City of Albuquerque

September 19, 1983

RE: 820 First Street NW (Dated September 14, 1983)

DRAINAGE PLAN

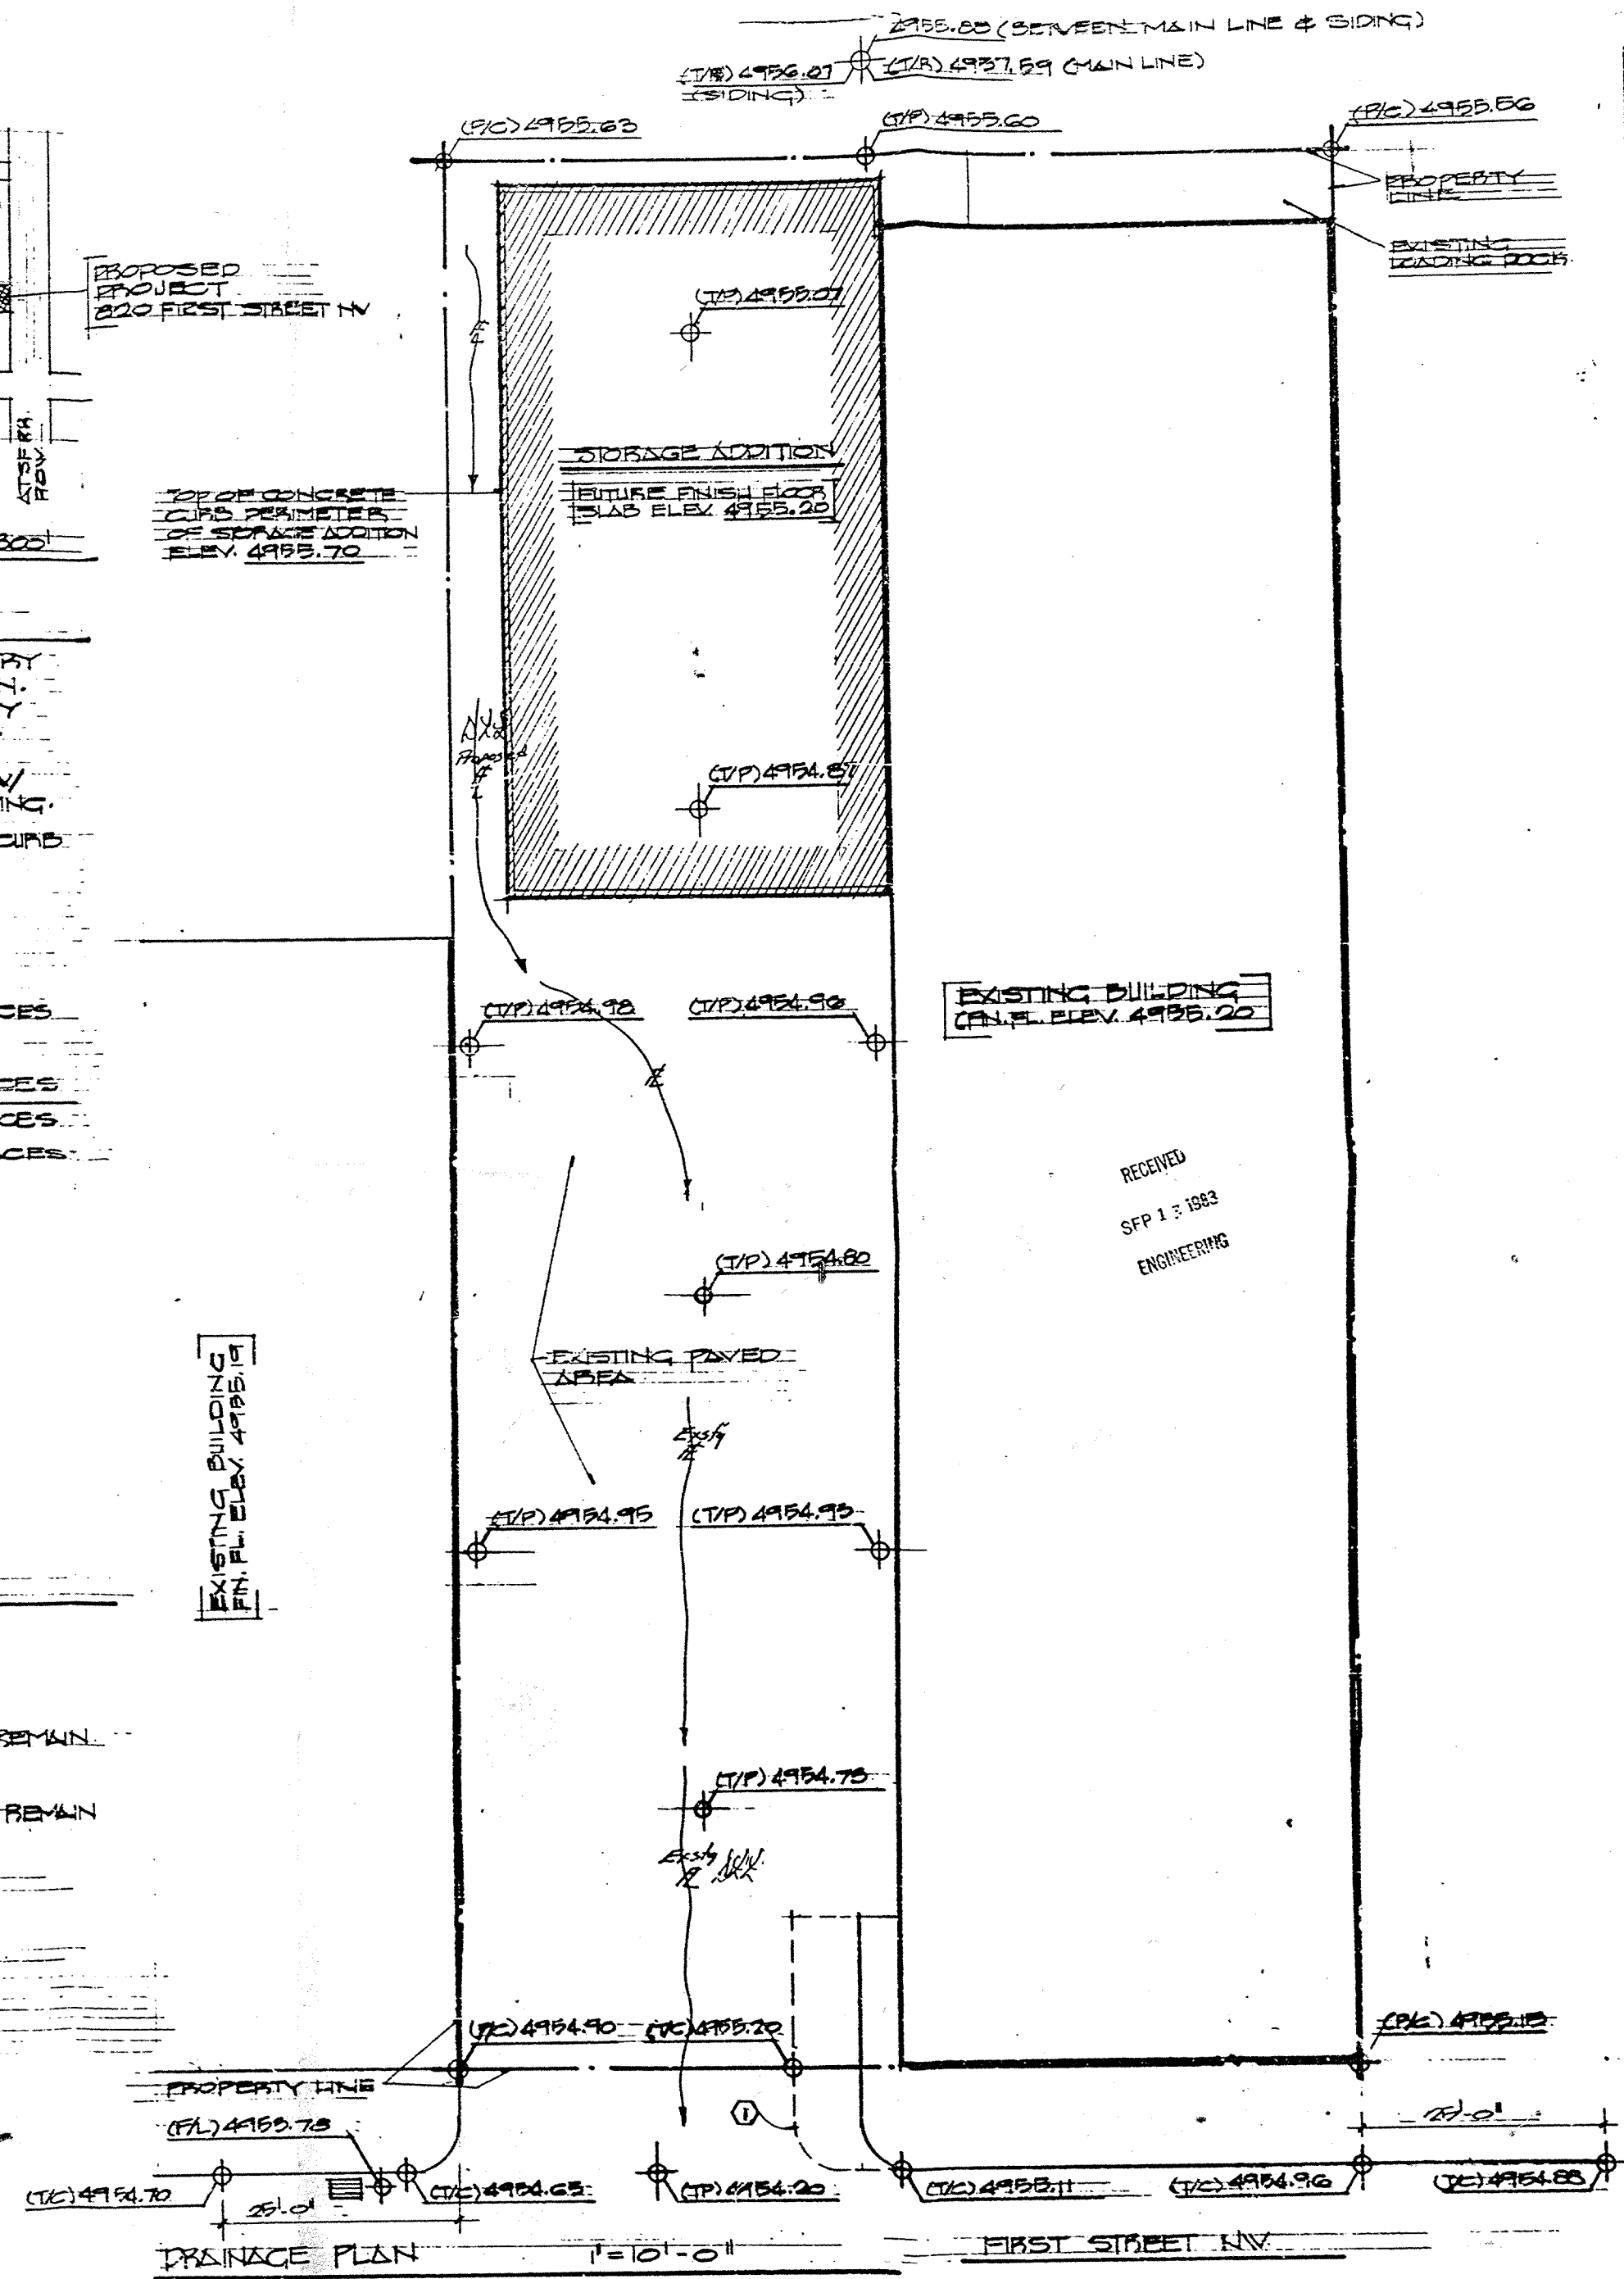
The referenced drainage plan is approved; however, I would recommend that your client raise the finished floor elevation one (1) foot above the top of the curb in view of the "A0" (Depth 1) zone designation for First Street as identified on the Flood Insurance Rate Maps. The building plans will be signed off with the inclusion of the approved plan in the building set.
